**SSD 6010 - One Residential Building (Student Accommodation) within
Darling Drive Plot**

Submission by:

Joan Wong

28 July 2013

SHADOW DIAGRAMS: PLAN SHOWING THE HAYMARKET, WINTER SOLSTICE

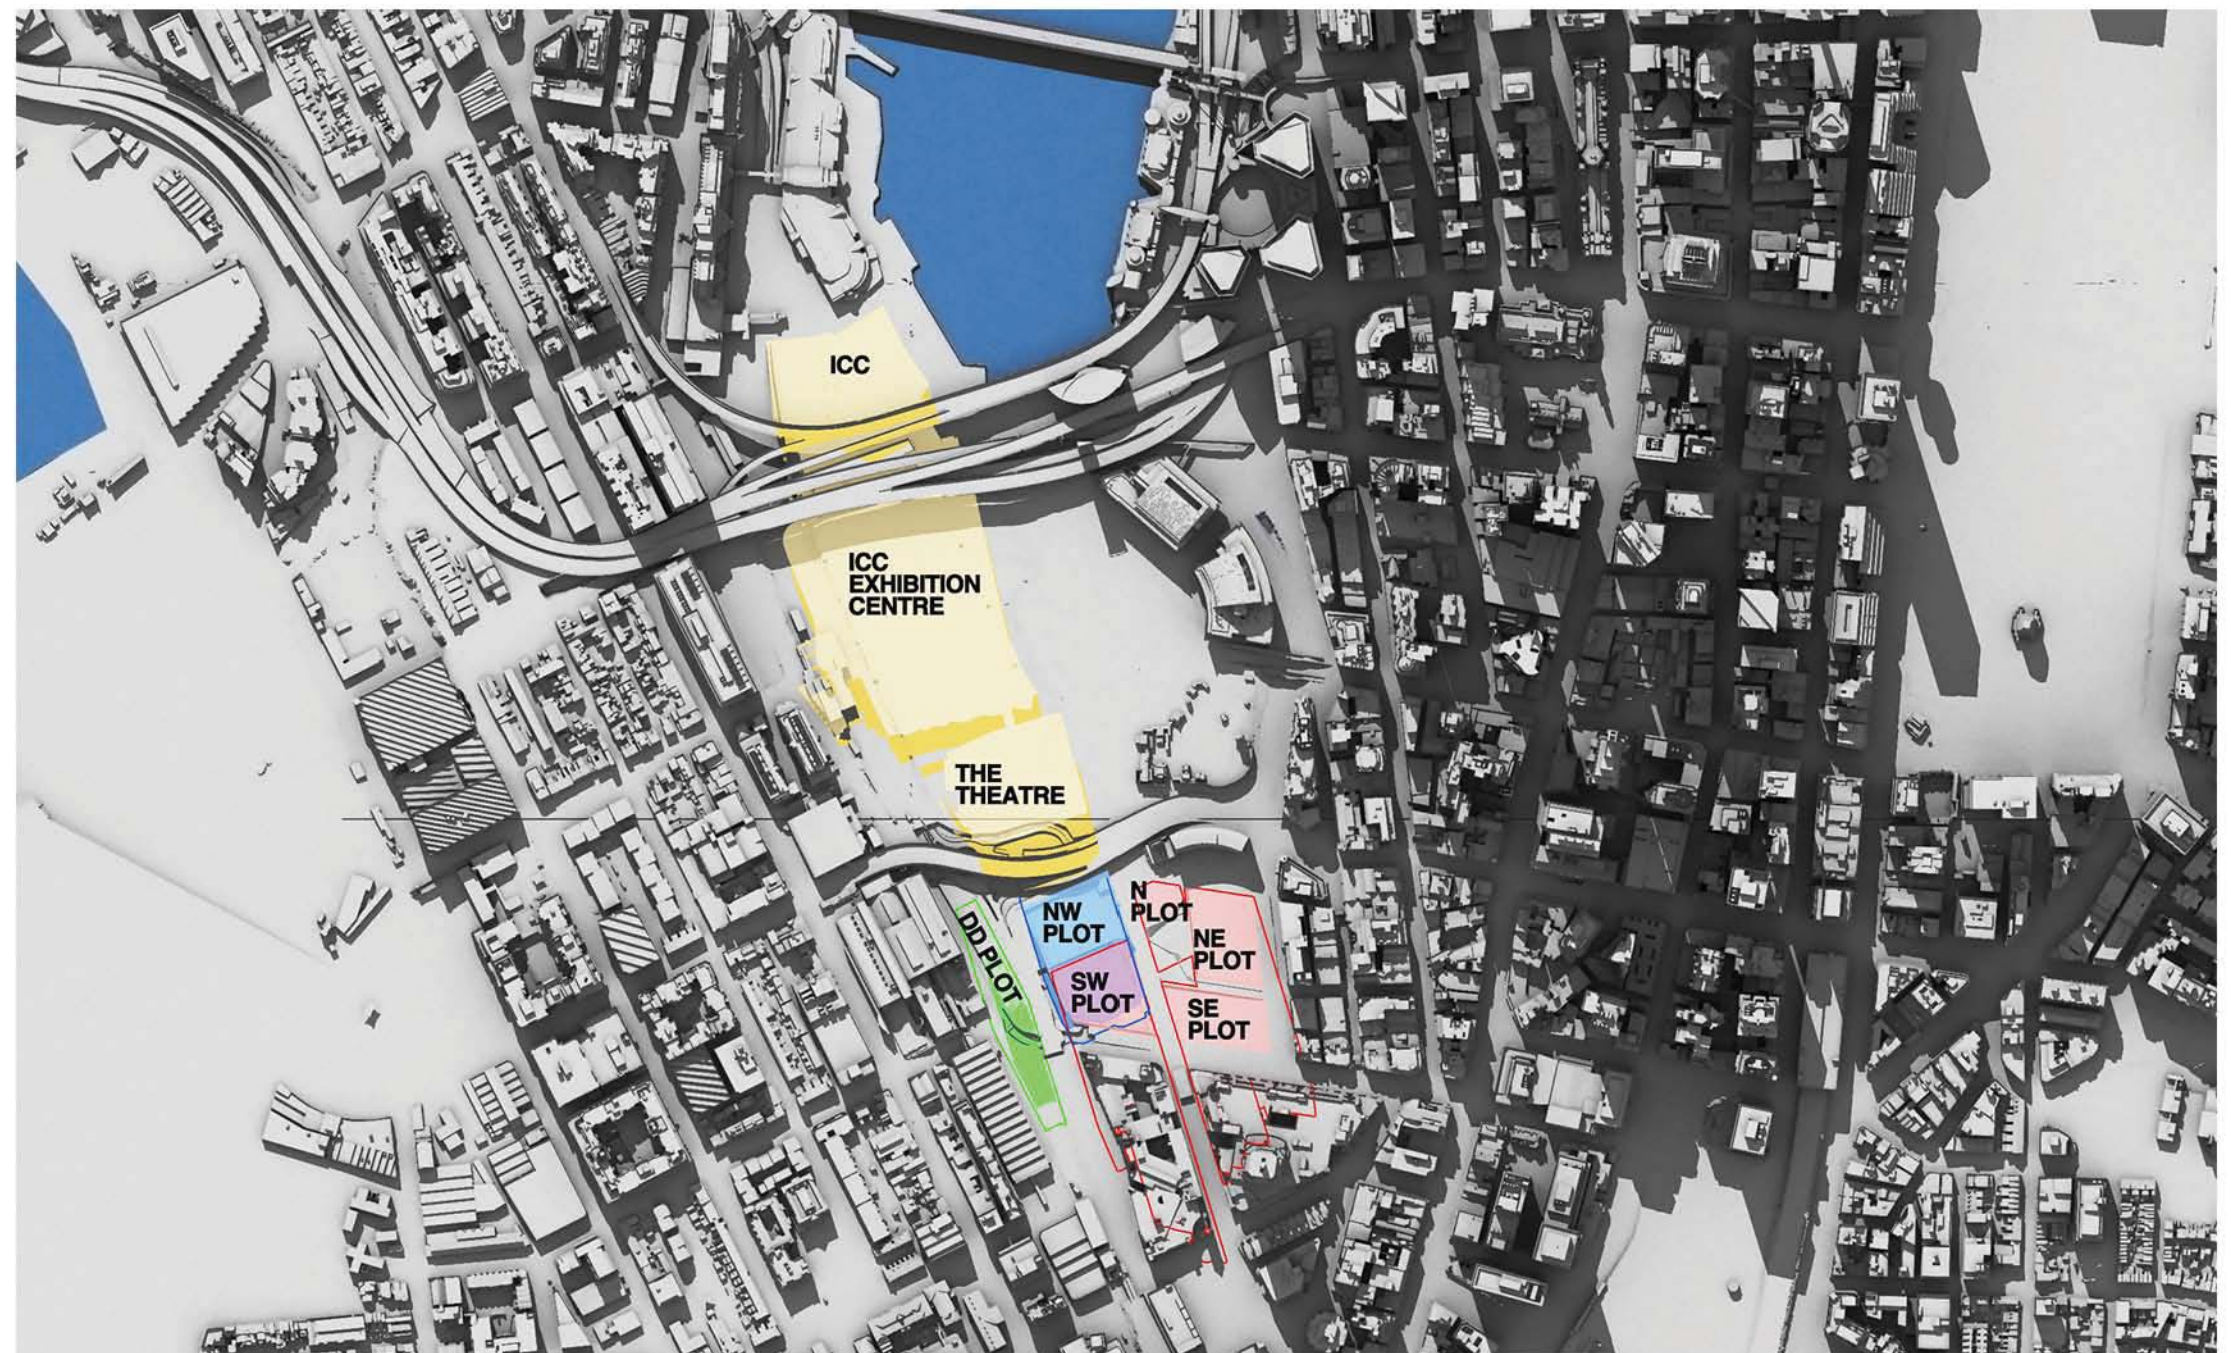
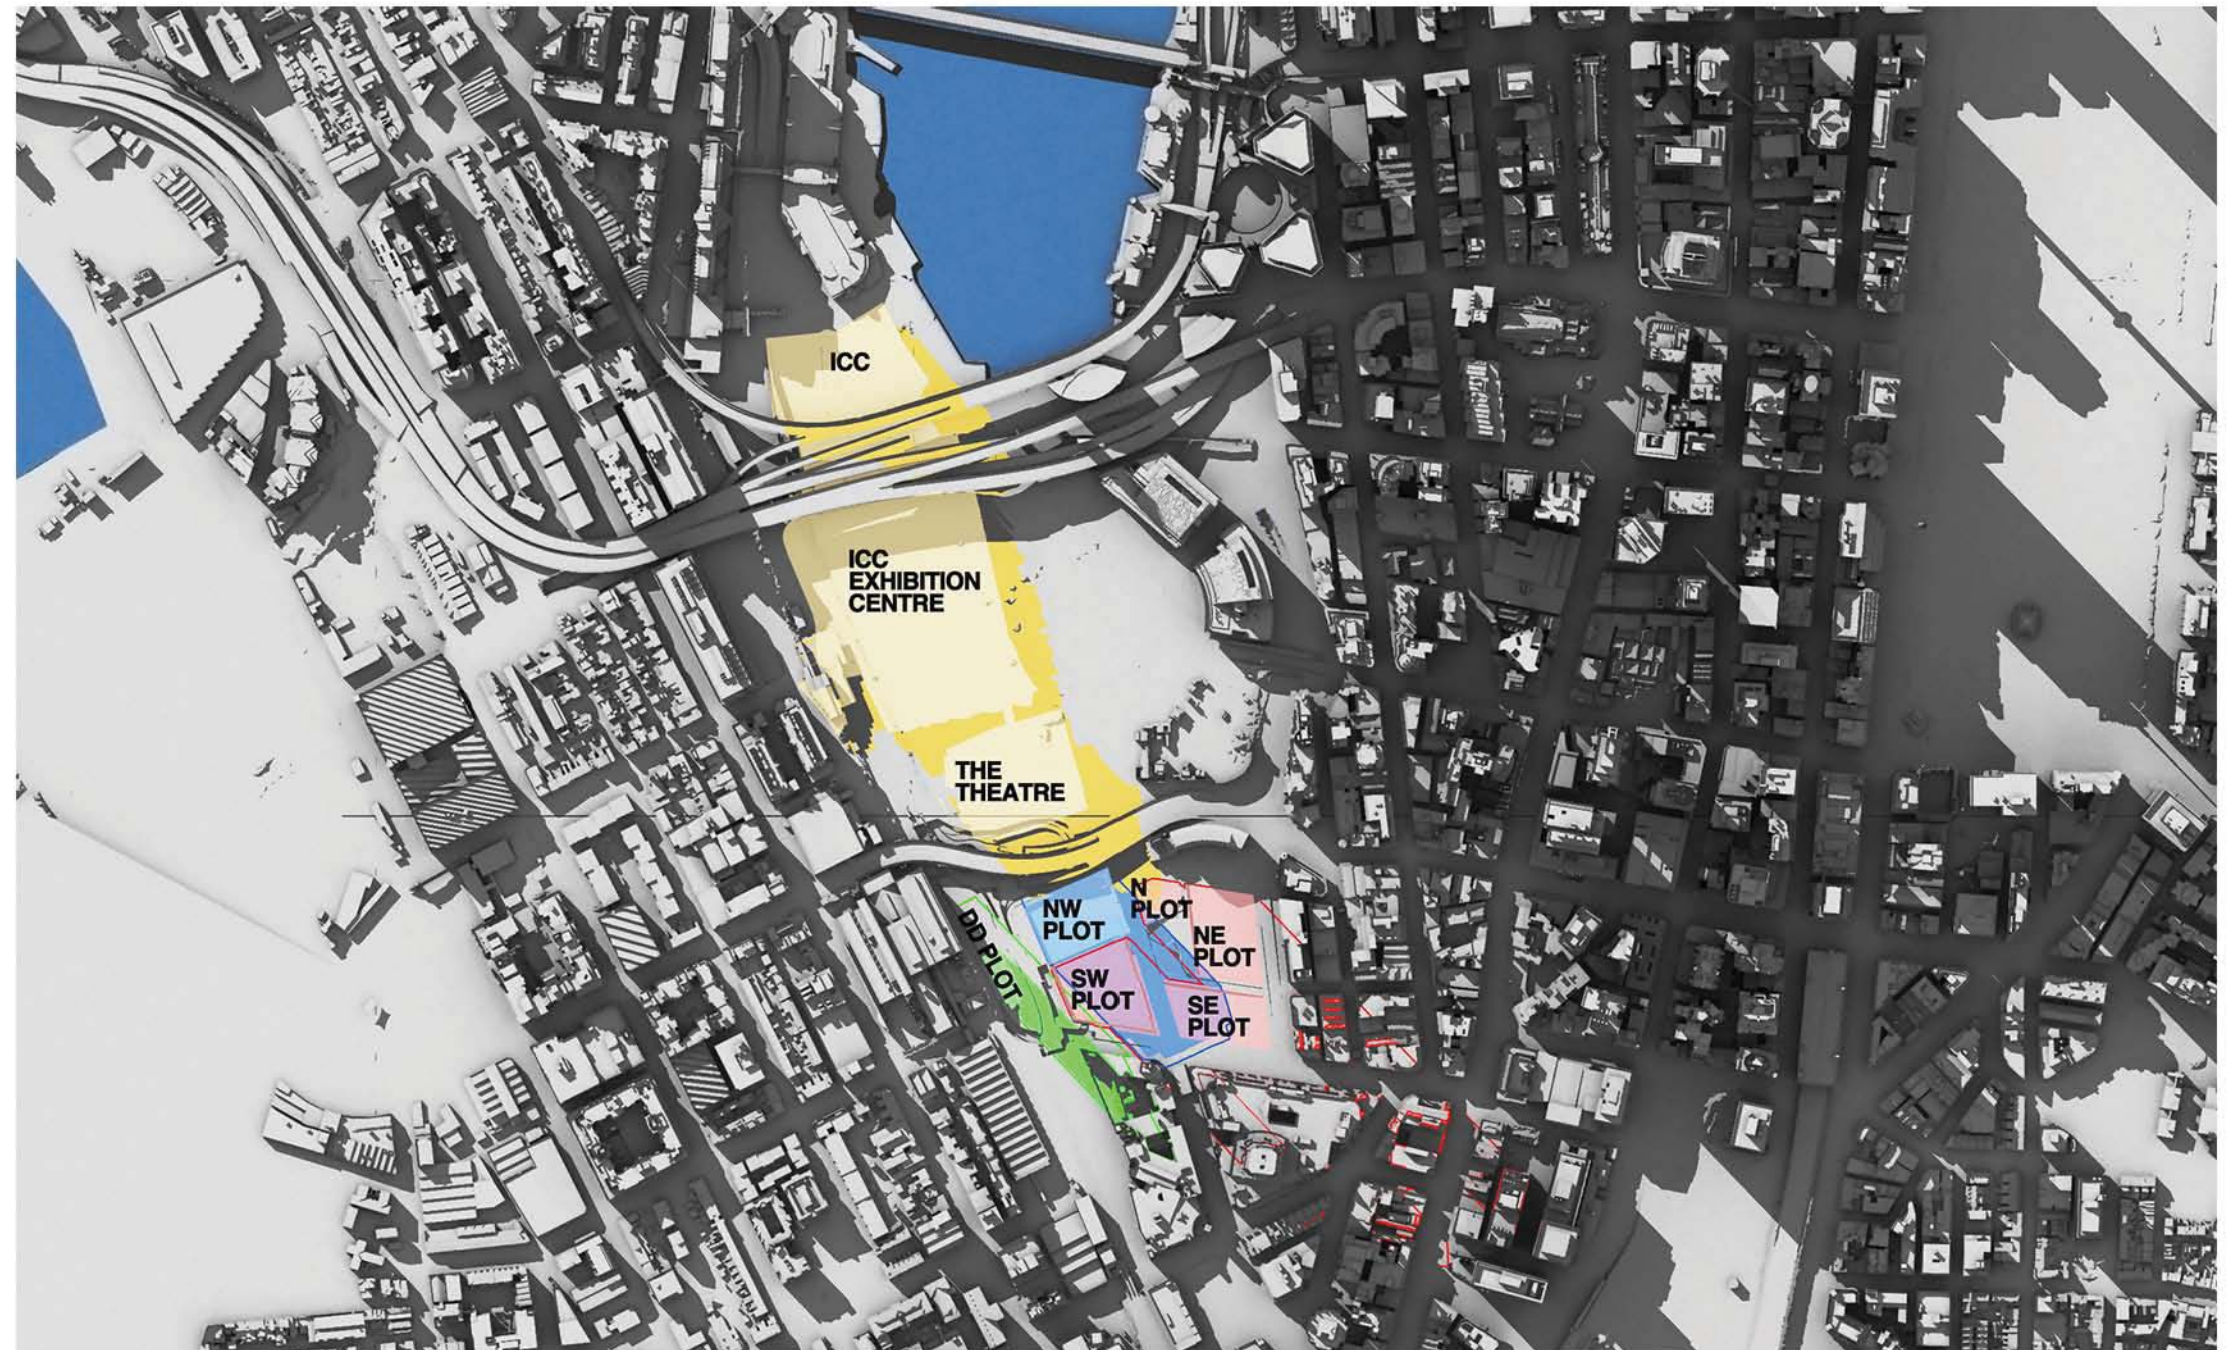
Proponent statement	Location of statement	Actual fact
<i>At mid-winter (22 June) there is some additional overshadowing impact to the Markey City podium and to the western elevation of The Peak Apartments after 2 pm. There is no additional overshadowing during the morning period, or the early afternoon.</i>	SSD5878 Response to Submissions and Amendments to Proposed Development Report, July 2013, Section 2.8 Overshadowing	That statement is misleading; in fact the podium additional overshadowing starts at 9 am and increases throughout the morning and early afternoon.
<i>At mid-winter (22 June) By 4pm, approximately 45-50% of the western elevation is in shadow, however the shadow has substantially moved off the northern façade such that only approximately 15-20% of the façade remains in shadow.</i>	SSD5878 Response to Submissions and Amendments to Proposed Development Report, July 2013, Section 2.8 Overshadowing	That statement is false, as can be seen from the diagram. The proponent has confused the western and northern facades.

Proponent statement	Location of statement	Actual fact
Winter solstice - 22 June <i>9:00 - 1.00 NO IMPACT</i>	SSD5878 Appendix H. Supplementary Design Report, Section 6. Amendments Winter solstice - 22 June	That statement is false; in fact the podium roof additional overshadowing starts at 9 am and increases throughout the 9 am to 1 pm period (and continues to increase thereafter)
Winter solstice - 22 June <i>2:00 – The western edge of the Market City podium roof is overshadowed</i>	SSD5878 Appendix H. Supplementary Design Report, Section 6. Amendments Winter solstice - 22 June	Most of the western and northern podium roof is overshadowed.
Winter solstice - 22 June <i>3:00 – The Market City podium roof is overshadowed from the north west corner to the Peak Tower;</i>	SSD5878 Appendix H. Supplementary Design Report, Section 6. Amendments Winter solstice - 22 June	Almost the entire podium roof is overshadowed.

Winter solstice - 22 June <i>4:00 – The Market City podium roof is overshadowed from the north west corner to the in front of the north elevation of the Peak Tower;</i>	SSD5878 Appendix H. Supplementary Design Report, Section 6. Amendments Winter solstice - 22 June	True, and this has substantially been the case since 2pm.
Winter solstice - 22 June <i>4:00 – 15-20% of the Peak Tower northern elevation remains in shadow since 3pm;</i>	SSD5878 Appendix H. Supplementary Design Report, Section 6. Amendments Winter solstice - 22 June	Actually 45-50% of the Peak Tower northern elevation remains in shadow since 3pm.
Winter solstice - 22 June <i>4:00 – A portion of the Peak Tower north elevation (15-20%) now receives direct sunlight when compared to the maximum building envelope model – portions of which were previously overshadowed at 3pm.</i>	SSD5878 Appendix H. Supplementary Design Report, Section 6. Amendments Winter solstice - 22 June	The reduction compared with the maximum building envelope model can be seen from the diagram to be only about 5-10%.

SHADOW DIAGRAMS: PERSPECTIVE, SHOWING THE PEAK, WINTER SOLSTICE

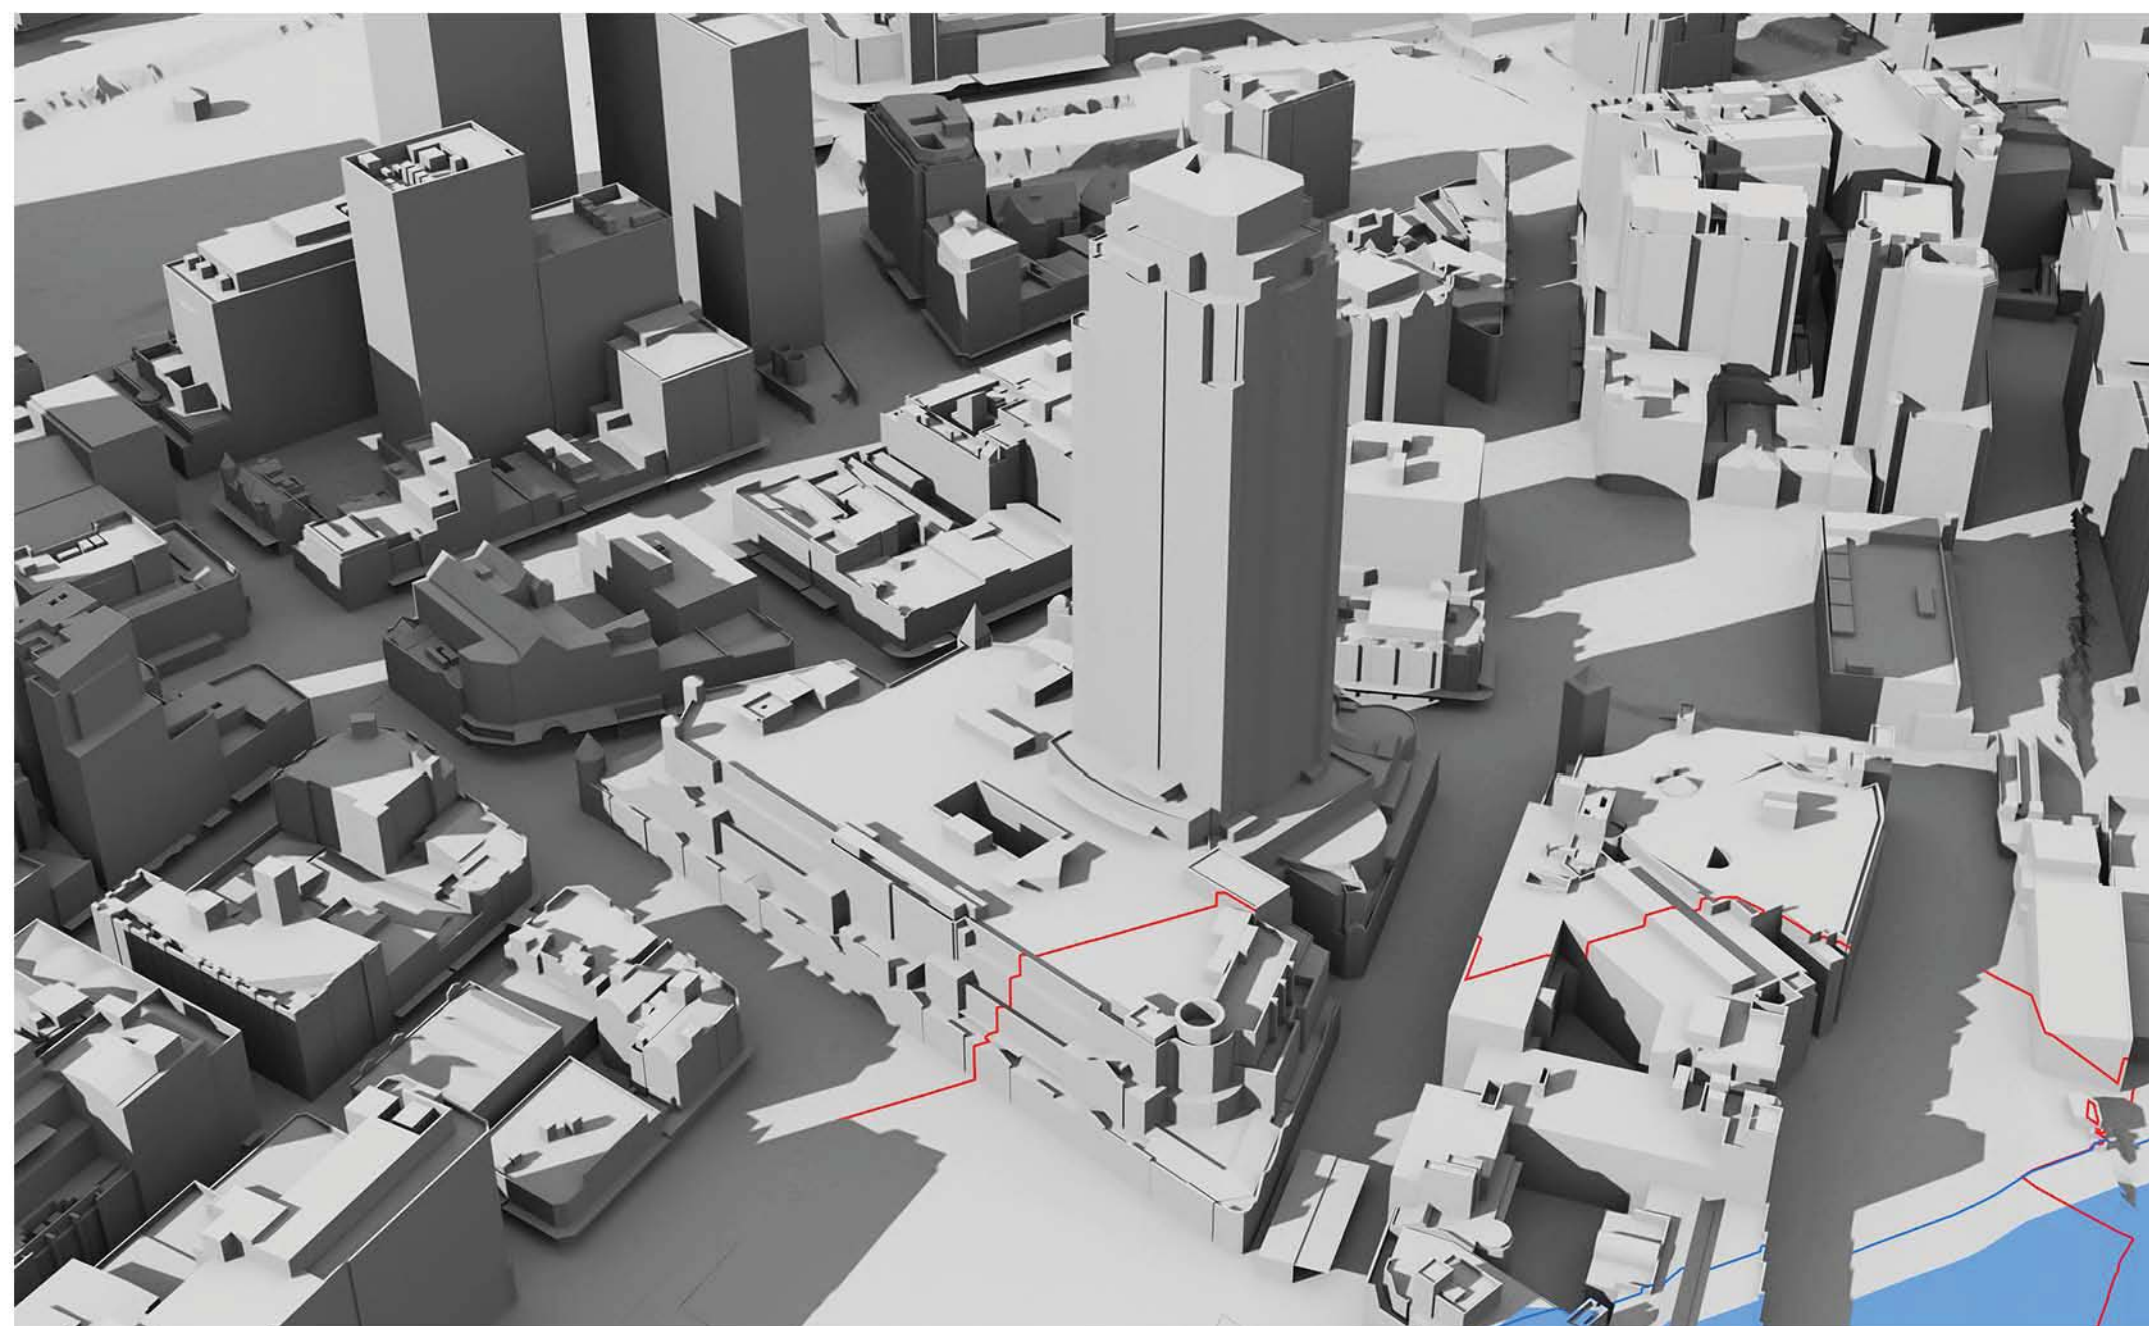
The proponent provides diagrams but fails to discuss the existing shadowing of the west façade of The Peak.

At 9am, 10am and 11am the west façade is totally in shadow due to other parts of The Peak building itself.

It can be concluded that some single aspect apartments on the west façade and some south-west dual aspect corner apartments currently receive less than 2 hours direct sunlight to habitable rooms and 50% of the private open space between 9am and 3pm on 21 June.

At 9am, 10am and 11am the west façade is totally in shadow due to other parts of The Peak building itself.

At 1pm the existing shadowing has been substantially, although not entirely, removed. However, overshadowing of lower levels of the west façade by the concept proposal parameter plan shadows for the N,NE and SE plots has already started.

By 2pm the existing shadowing has been totally removed. However, overshadowing of the west façade by the SSDA4 and SSDA5 buildings has appeared and risen further up the west façade than the concept proposal parameter plan shadows for the N,NE and SE plots, which is still present.

It can be concluded that, as a result of combination of the proposed development with existing shadowing of the west façade, some single aspect apartments on the west façade and the south-west dual aspect corner apartments which currently receive less than 2 hours direct sunlight to habitable rooms and 50% of the private open space between 9am and 3pm on 21 June will suffer additional overshadowing. It is beyond our skills to count the number of such apartments. We note that the proponent has made no attempt to do so.

Rather than counting the number of units which will not meet the DCP guidelines, the proponent attempts to trade-off direct sunlight at 4pm for lack of direct sunlight during the period 9am to 3pm. There is no provision in the DCP guidelines for such a trade-off.
